SMOKE STACK AT STERLING RANCH

SMOKE STACK AT STERLING RANCH REZONE

REZONE EXHIBIT

V1_ Zone map comments -2310.pdf Markup Summary

REZONE EXHIBIT

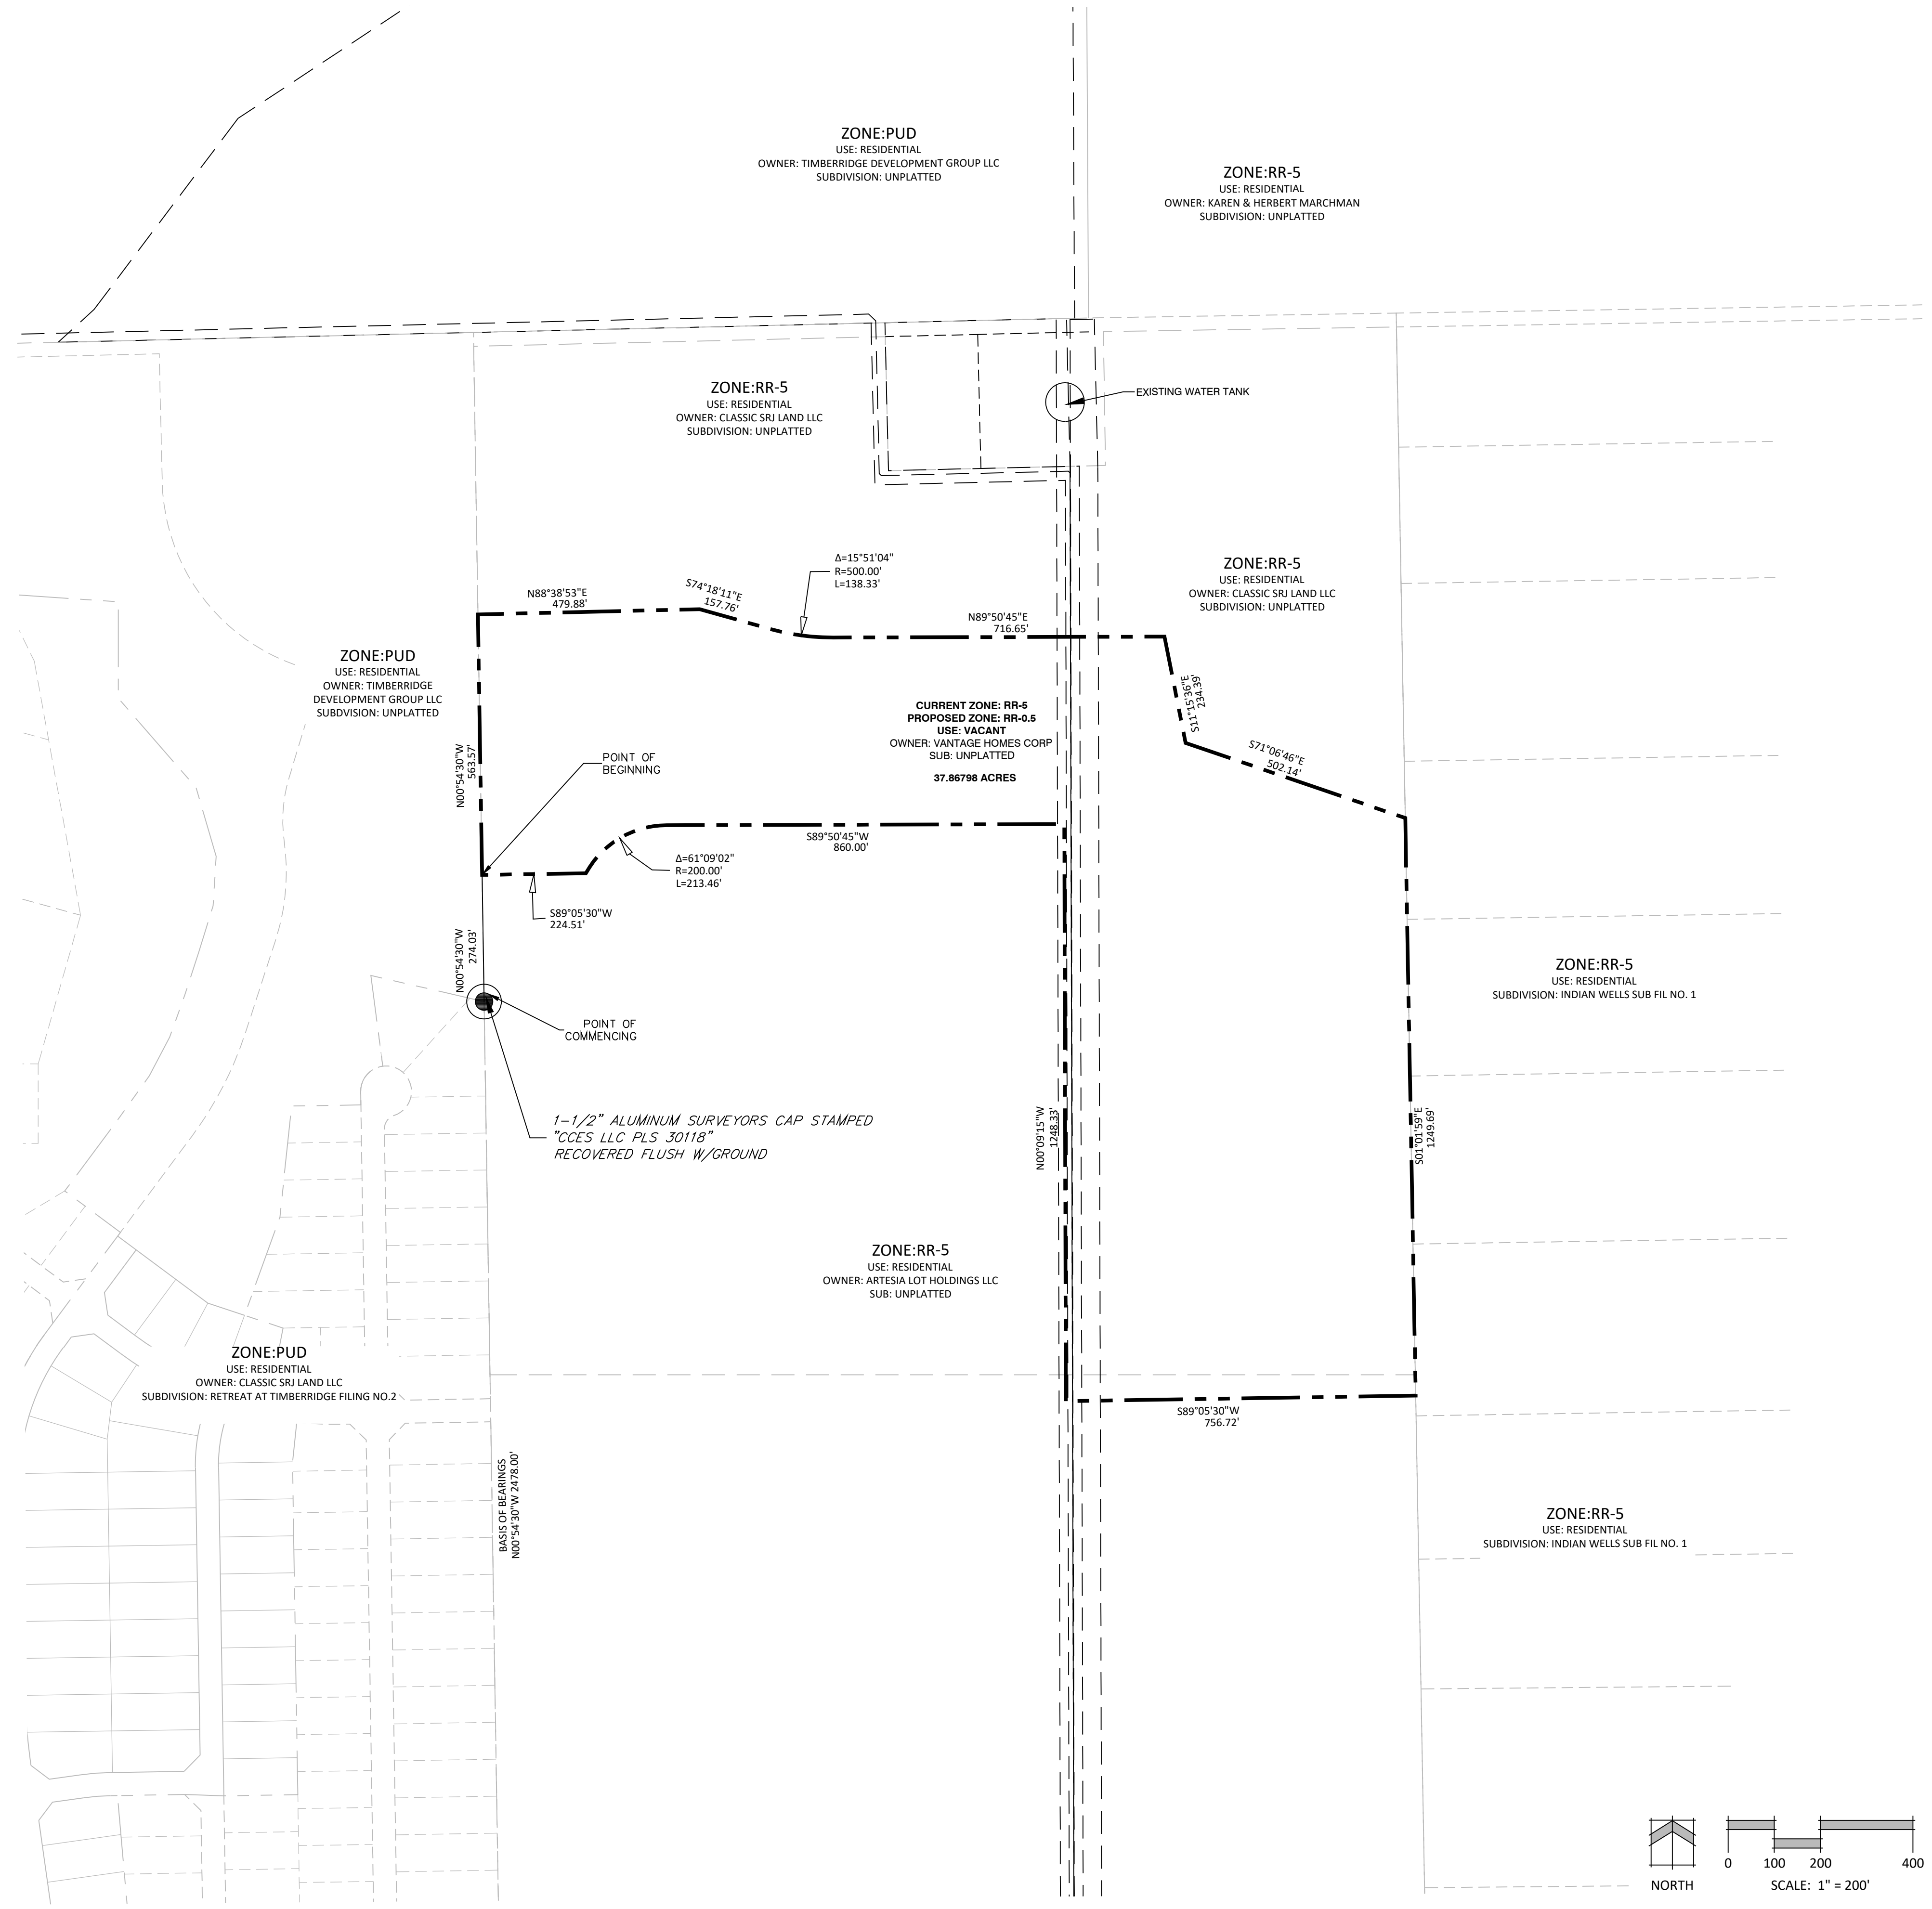
Add existing easements, etc. per checklist please

please identify subdivision names for clarity

provide acreage

EASEMENT

2023 file if approved
